REQUEST

Current Zoning: NC (neighborhood center)
Proposed Zoning: MUDD-O PED (mixed-use development, optional, pedestrian overlay)

Approximately 1.62 acres located on the east side of East Morehead Street, south of South McDowell Street, and west of Baxter Street.

The petition proposes a non-residential mixed-use development on a parcel that currently has numerous retail uses.

SITE PLAN

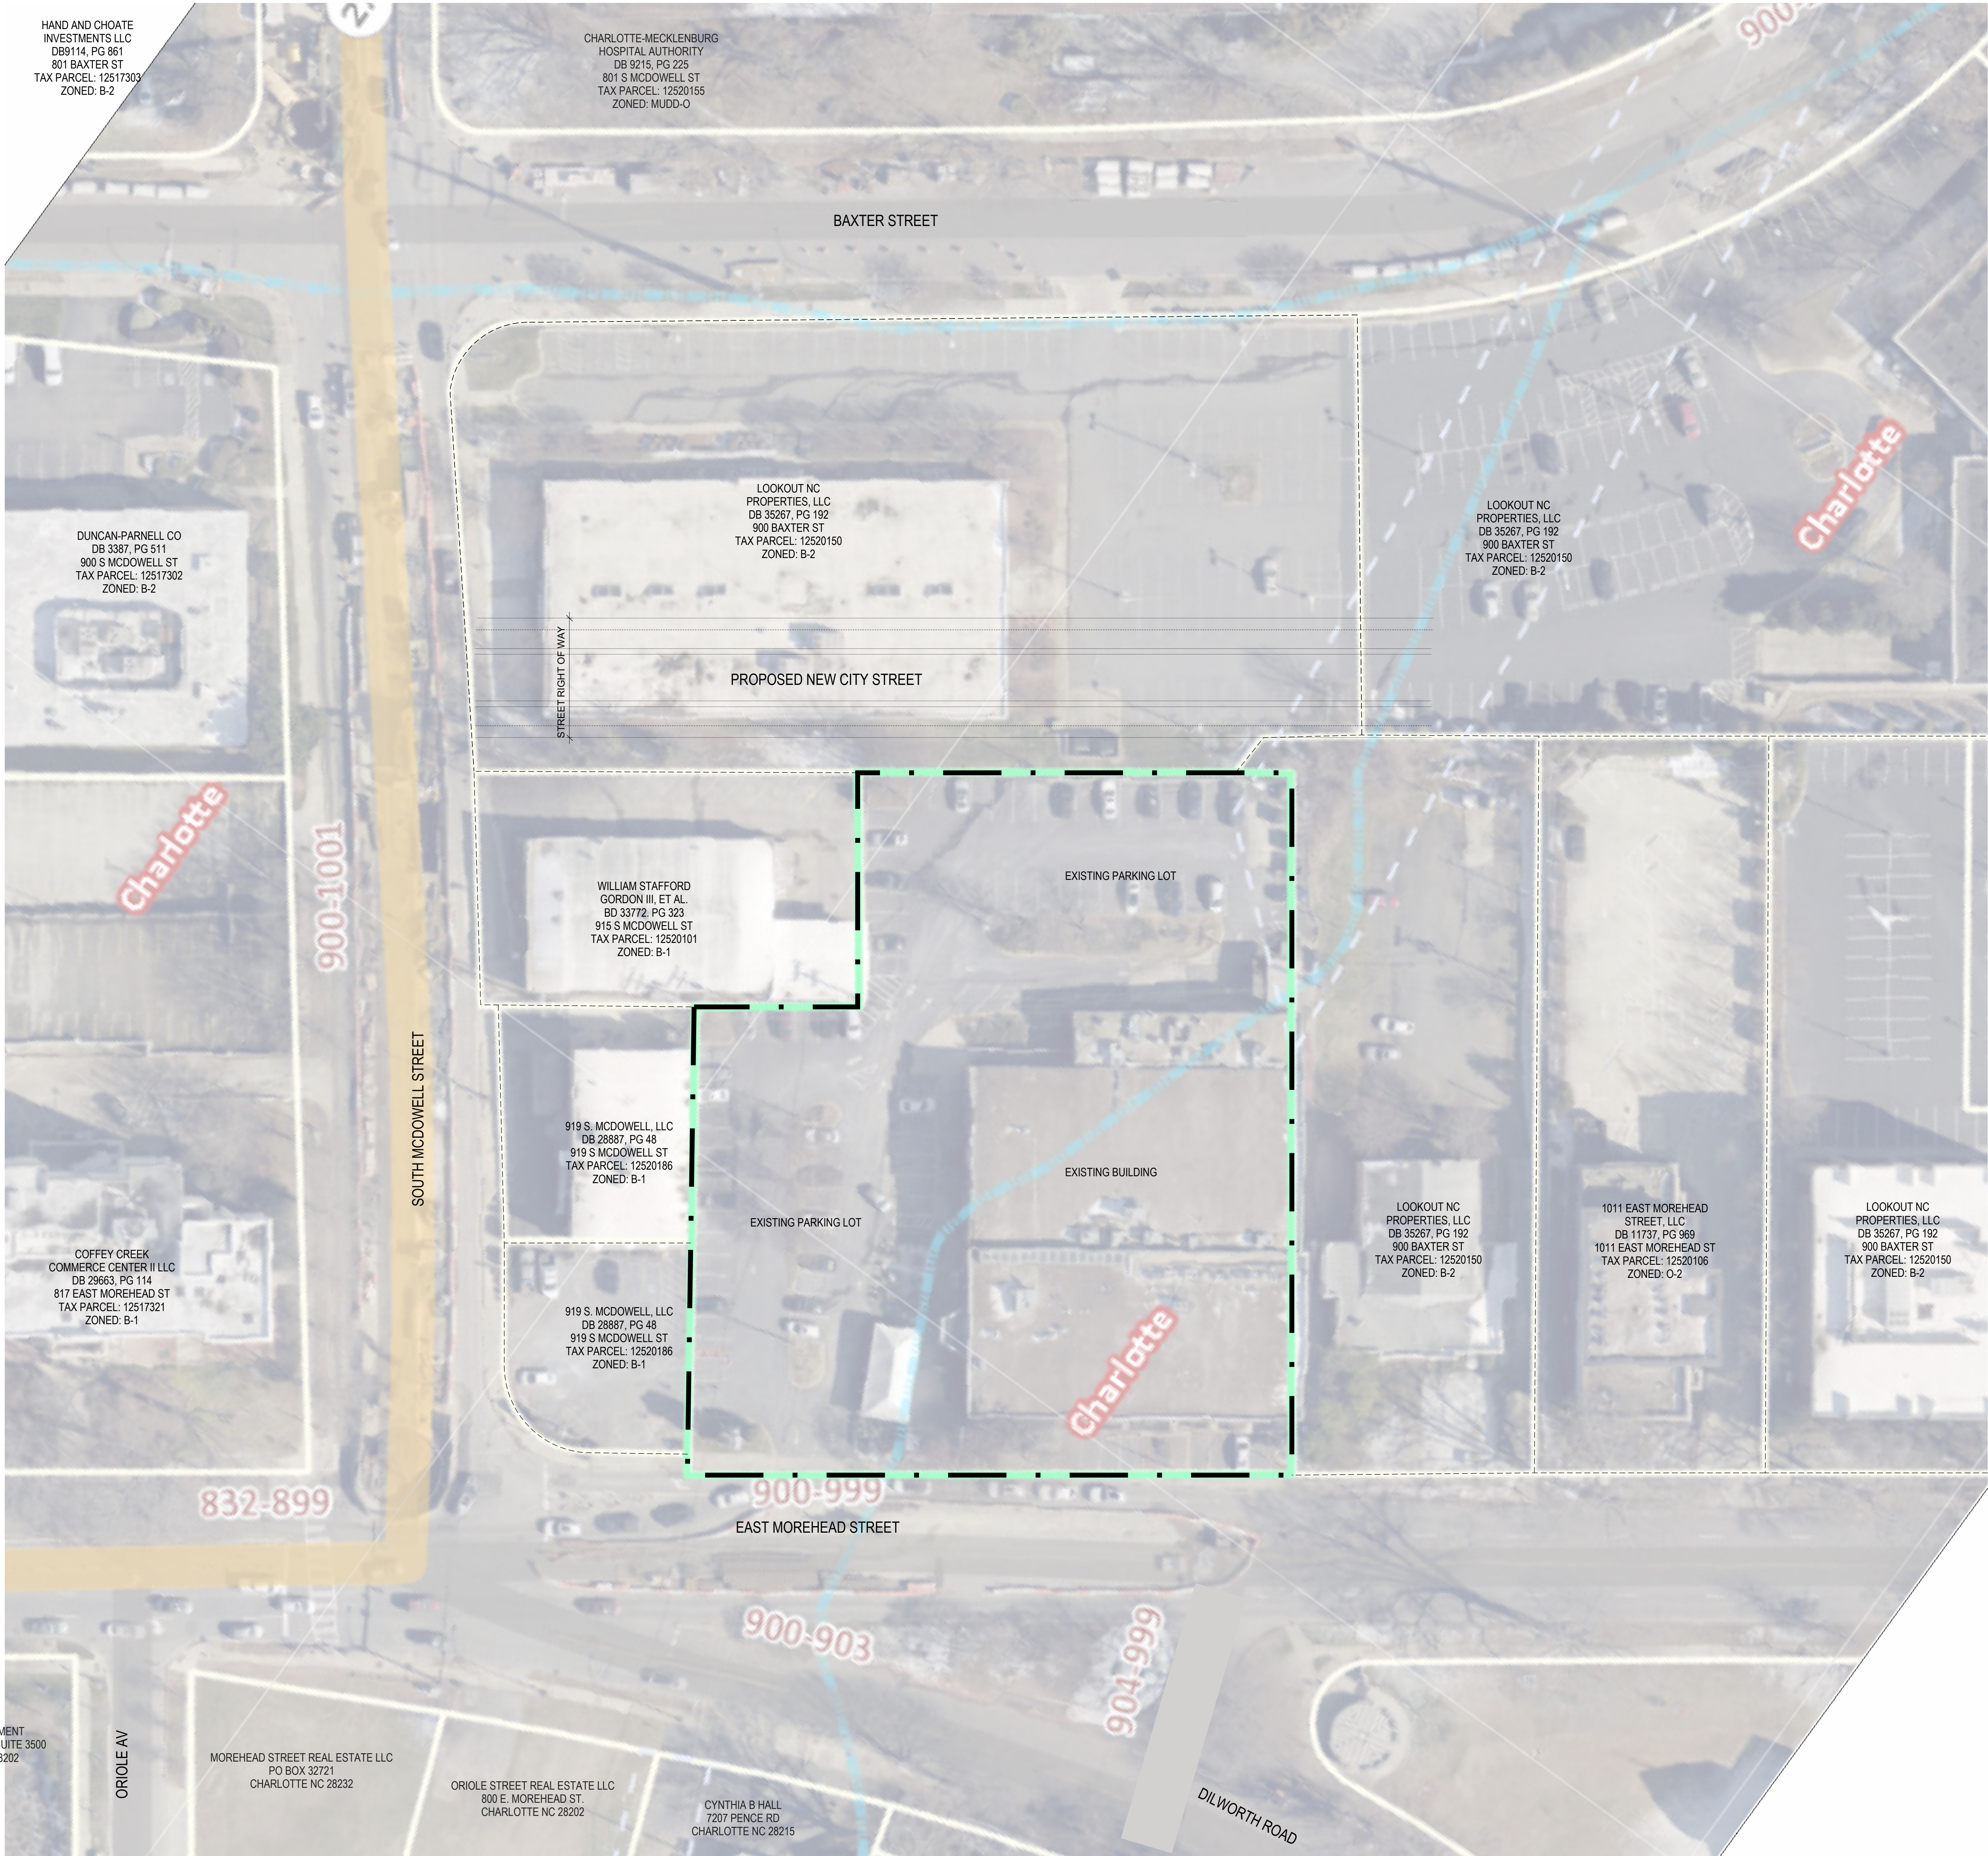
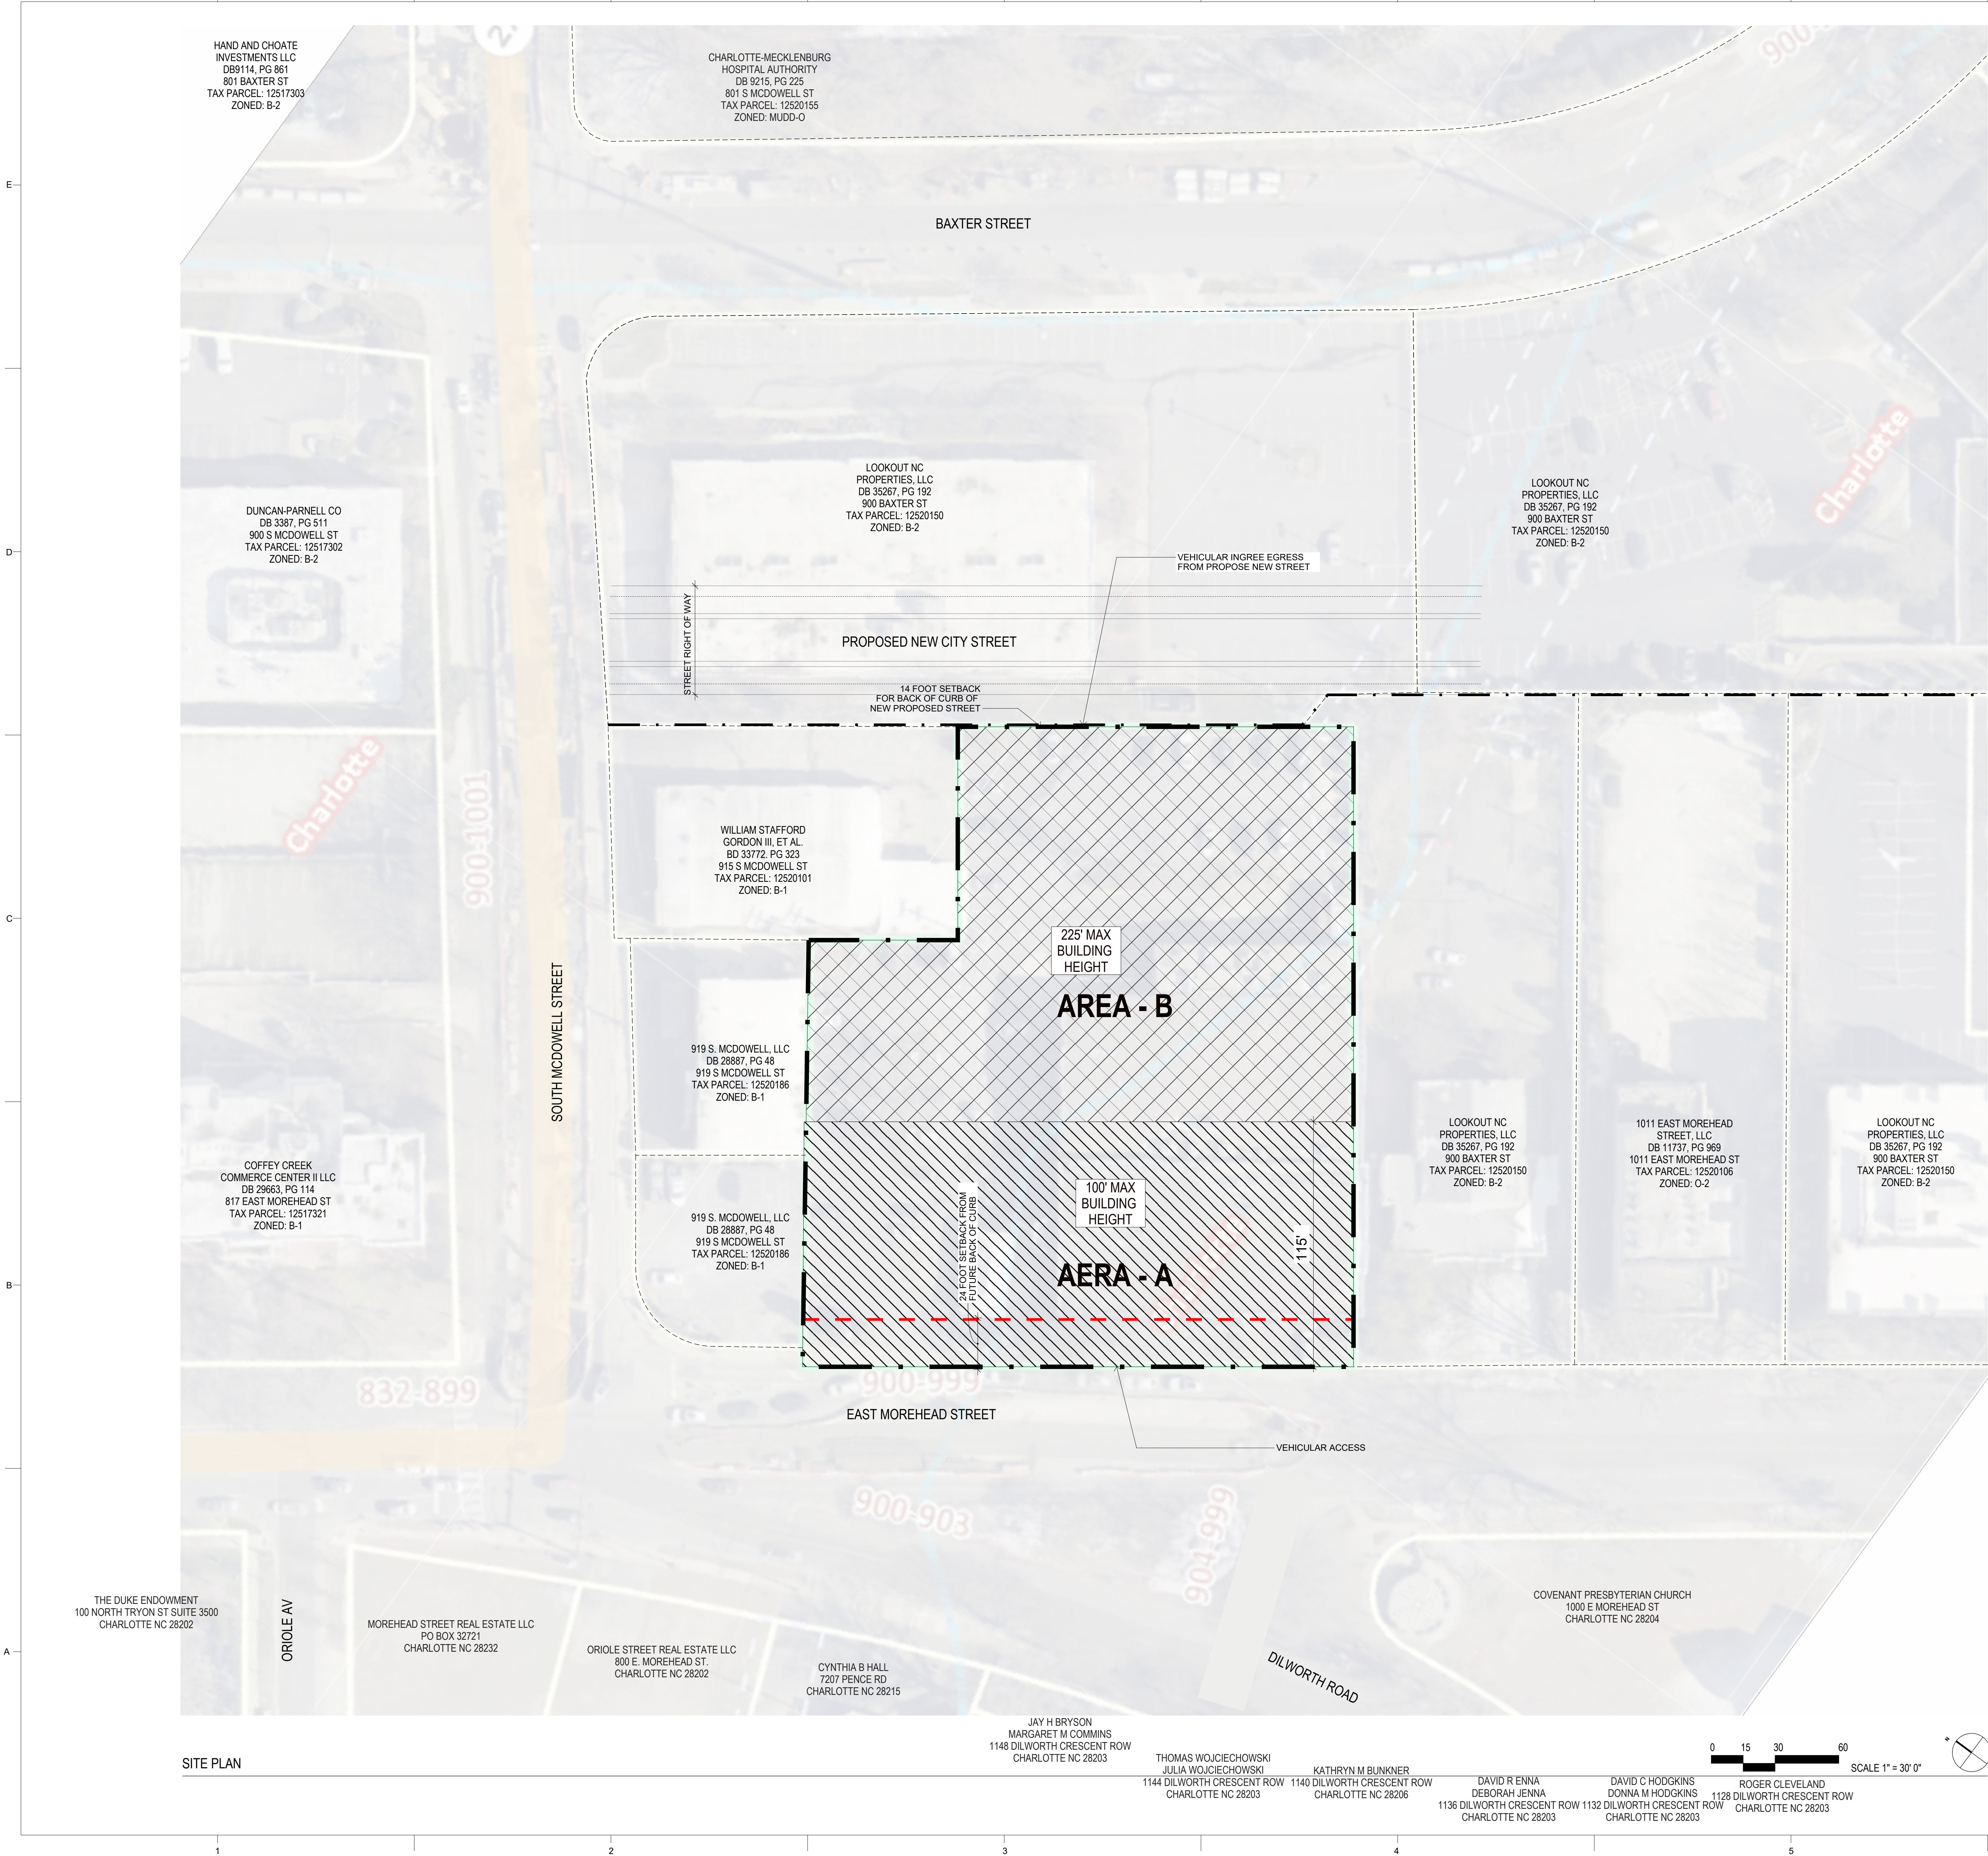
1. ~~Please provide additional notes on proposed public benefits that would justify the maximum height of 225'.~~ **Addressed**
